Our Reference: SYD14/01451/03 (A11283360)

Your Ref: SSD 6820

PROPOSED LIGHT WEIGHT AGGREGATE FACILITY
780 WALLGROVE ROAD, HORSLEY PARK

Roads and Maritime has reviewed the information submitted raises no objection to the Application. Roads and Maritime has the following comments for the Department's consideration in the determination of the application:

1 Masterplan
- 1 : 1000

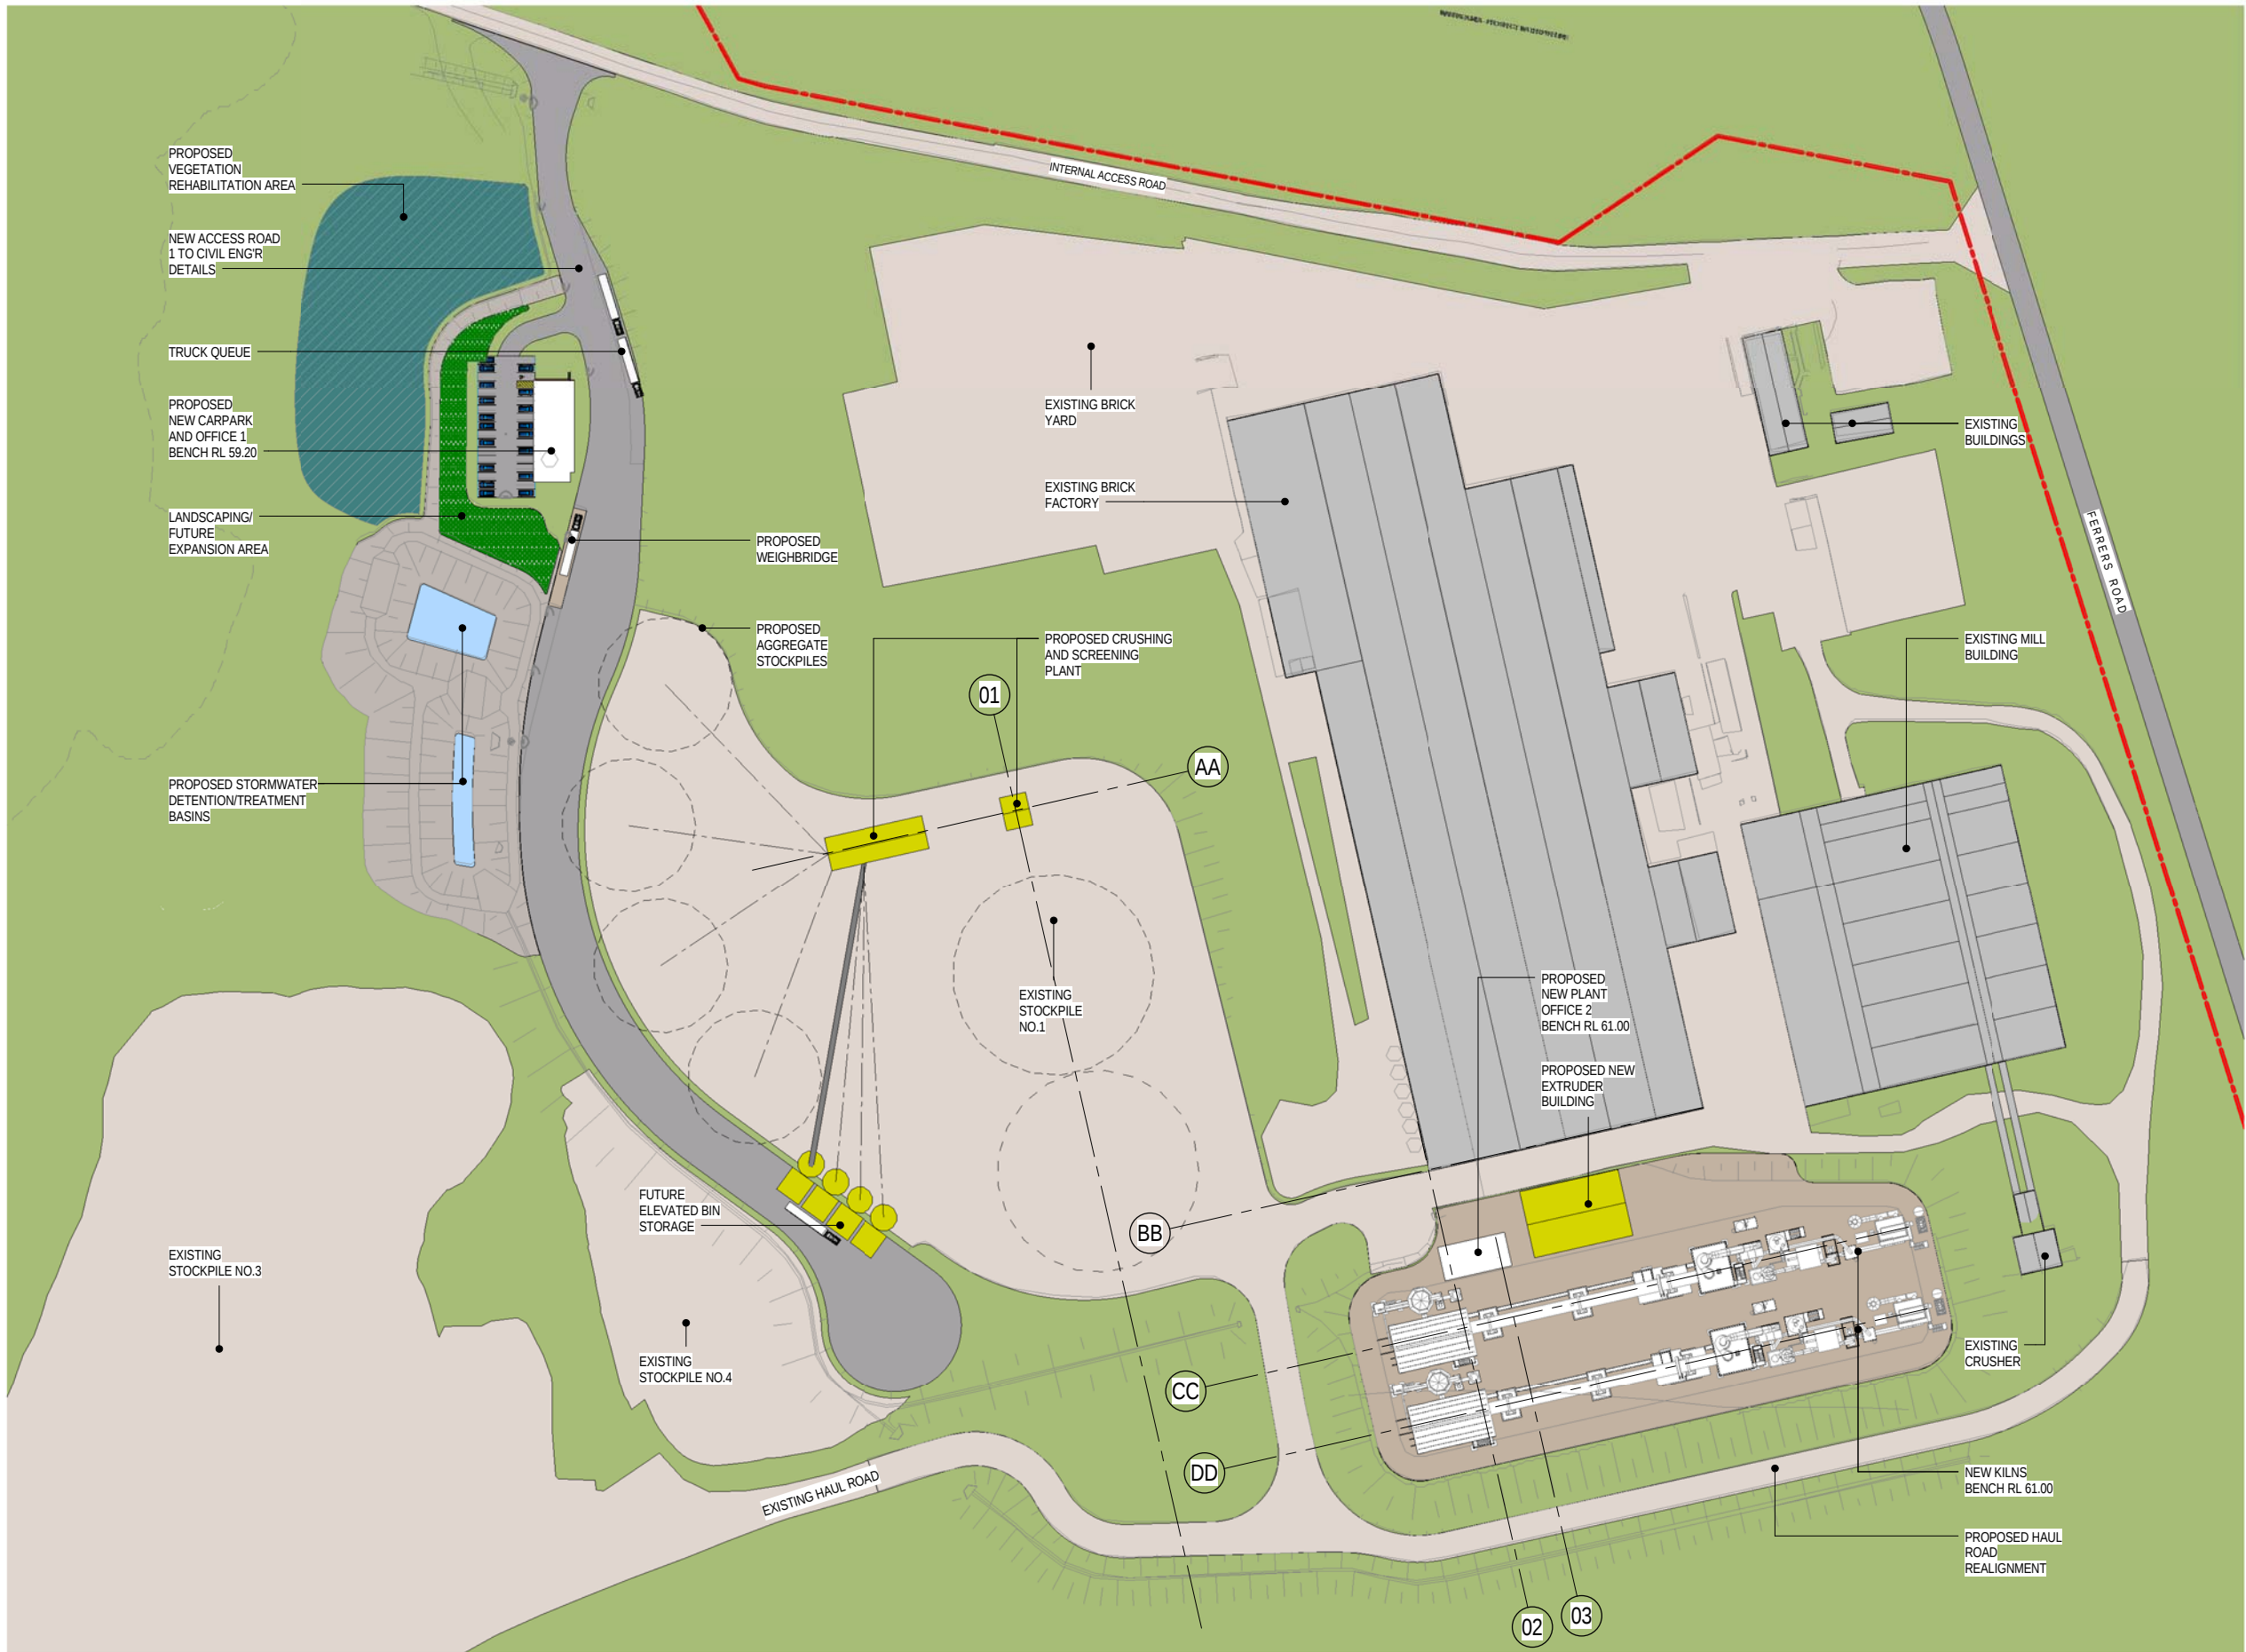
2. The layout of the proposed car parking areas associated with the subject development (including, driveways, grades, turn paths, sight distance requirements in relation to landscaping and/or fencing, aisle widths, aisle lengths, and parking bay dimensions) should be in accordance with AS 2890.1- 2004, AS2890.6-2009 and AS 2890.2 – 2002 for heavy vehicle usage.
